Mark E. Jones, PE
Structural Engineering and Design

Ref: Site Observations and Analysis
90 Cotton Fields Ln.
Fuquay-Varina, NC
Permit No. SFD2306-0047
Kay Ridge Plan
Project No. 17-028

1ST / 2ND FLOOR
PLAN

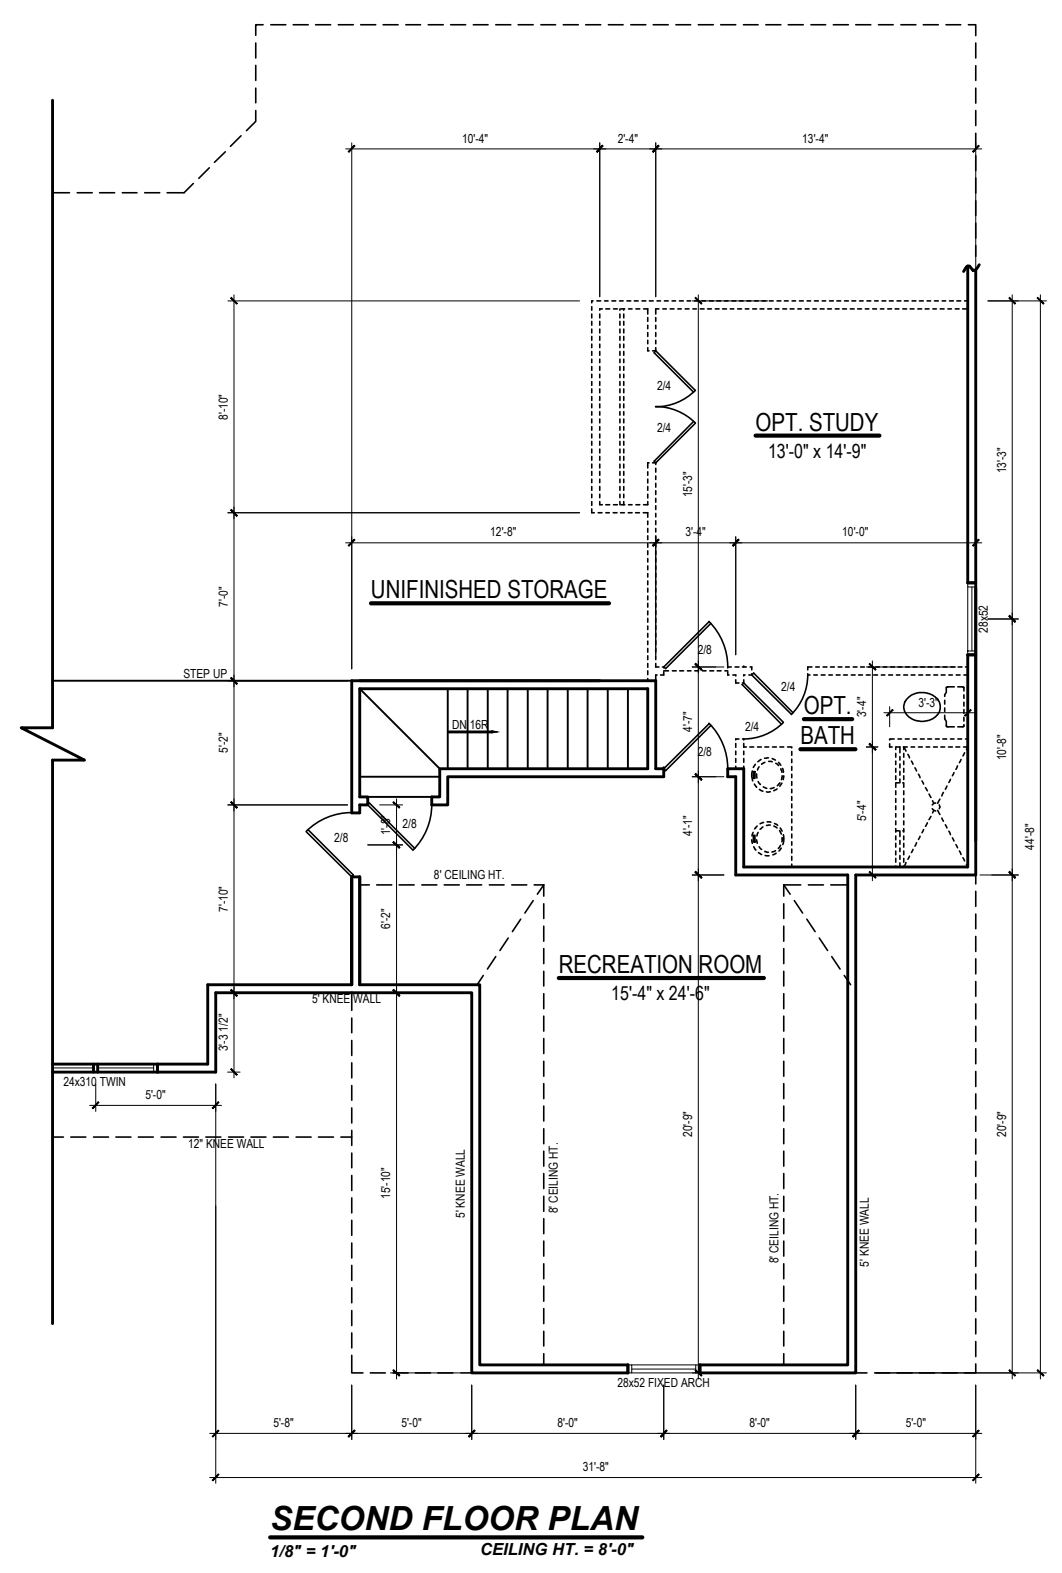
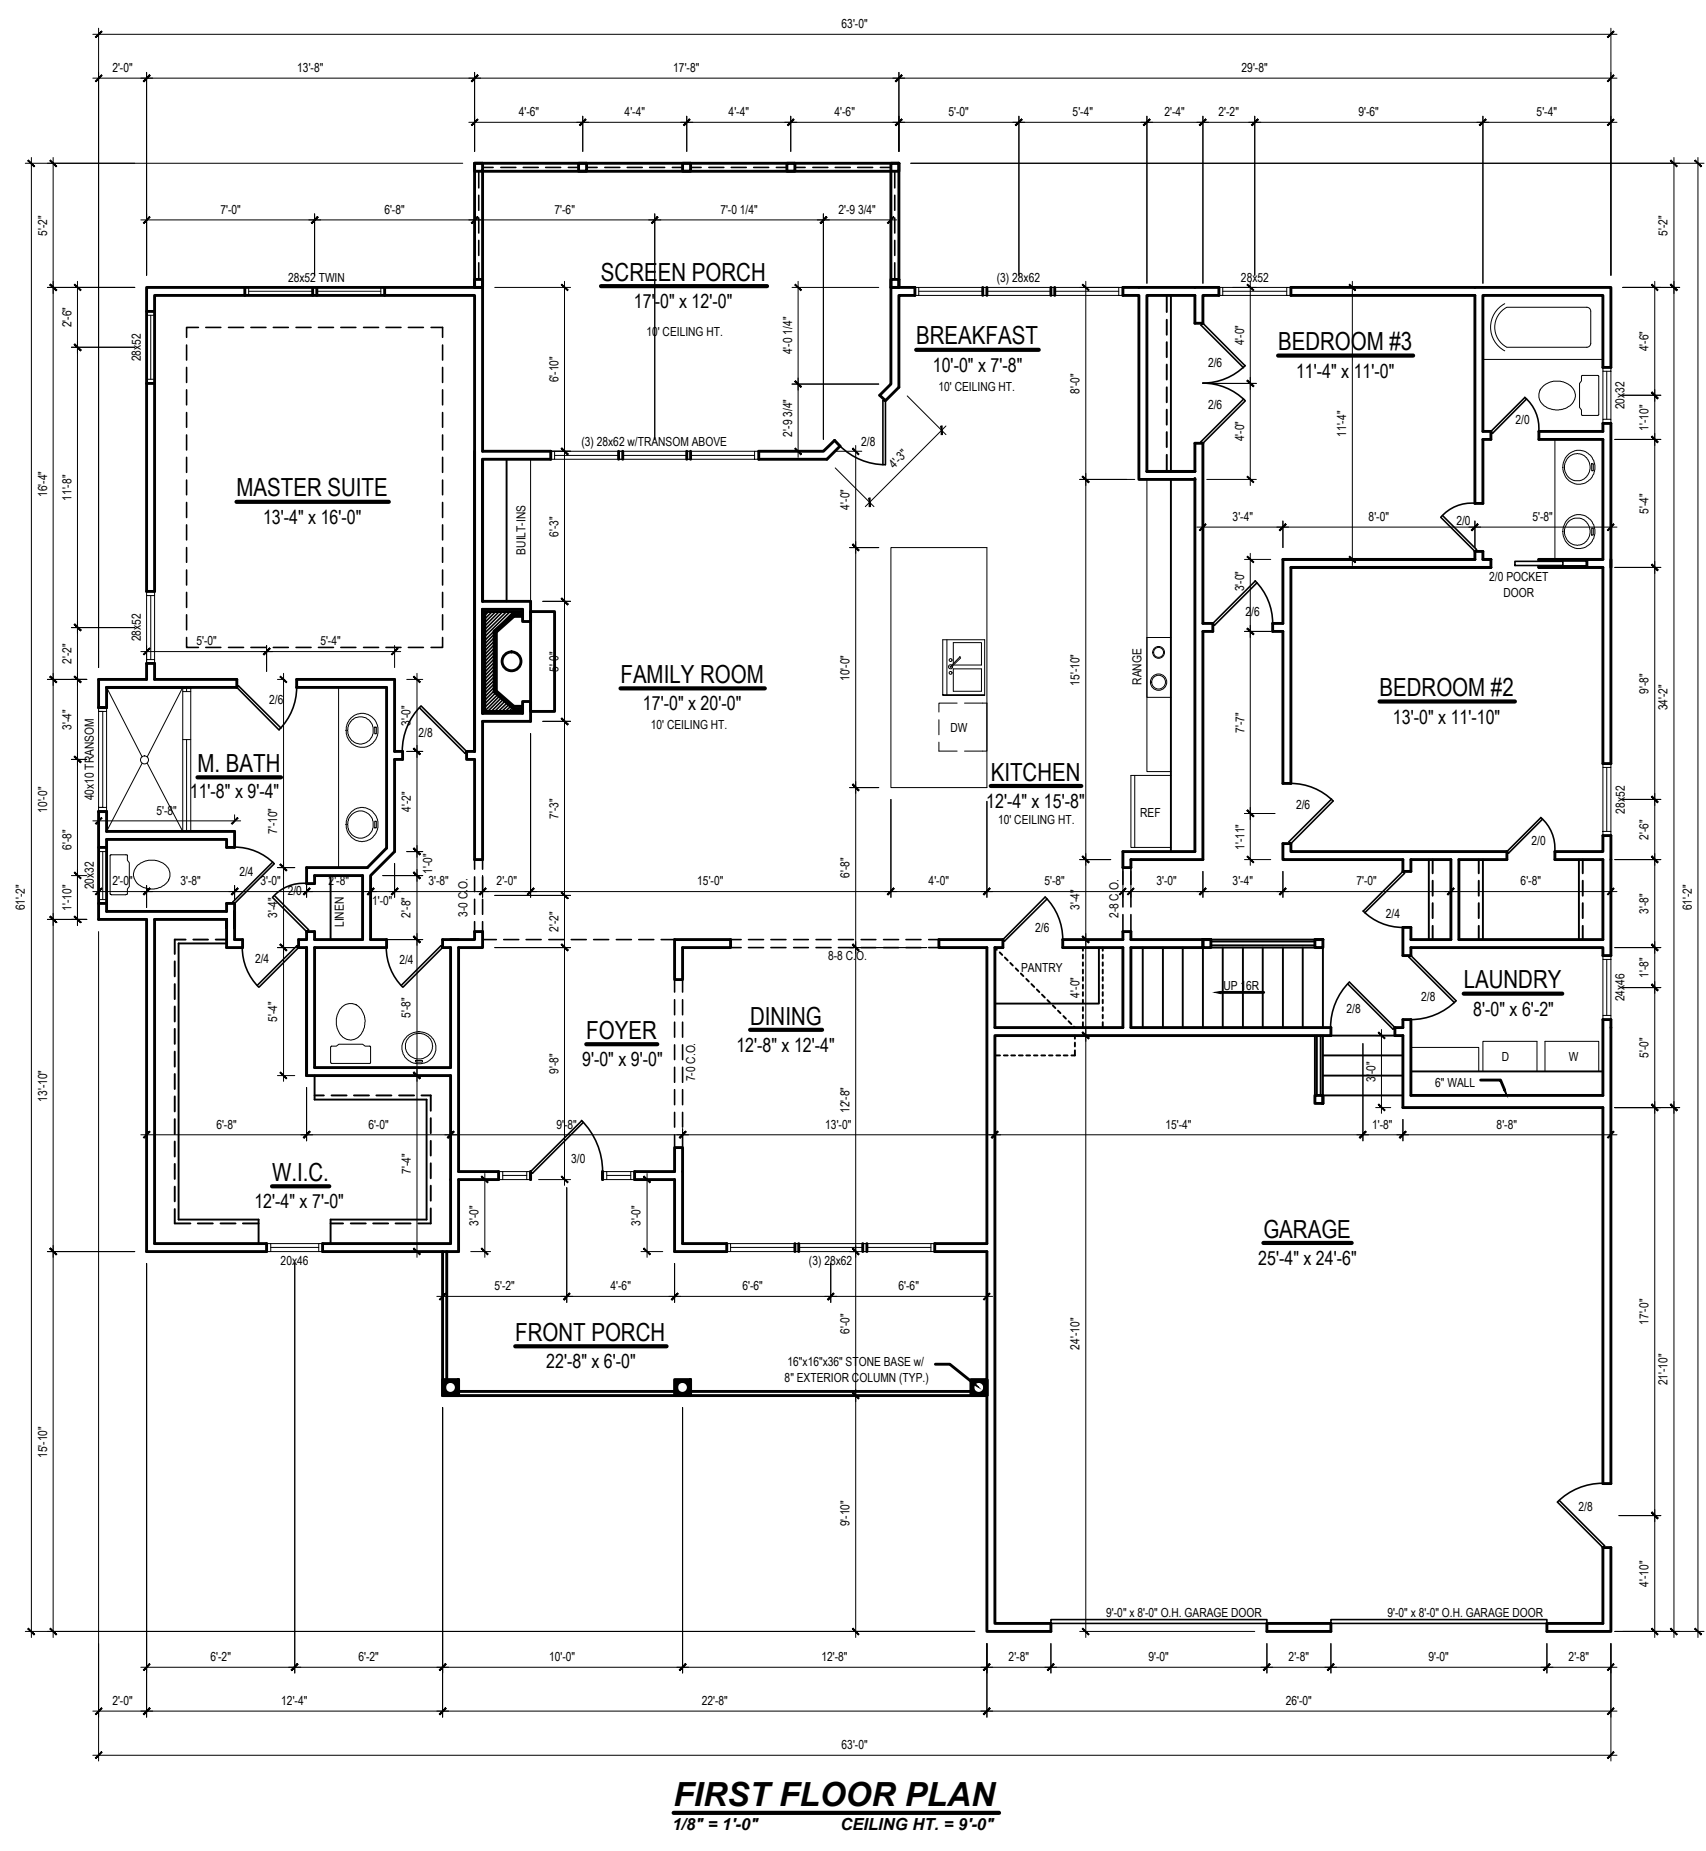
1. Plan calls for double 2x12 above the master shower. Double 2x10 installed.
3. Nails at dormer lvl hanger should be 16d or provide letter from PE that 1.5" #10 nail is sufficient.

1. The builder shall provide one additional 2x10 to the existing 2-2x10 beam above the master bath.
3. The 1.5" #10 nails in the hangers at the dormer lvl are sufficient to support the imposed loads. No action is required.
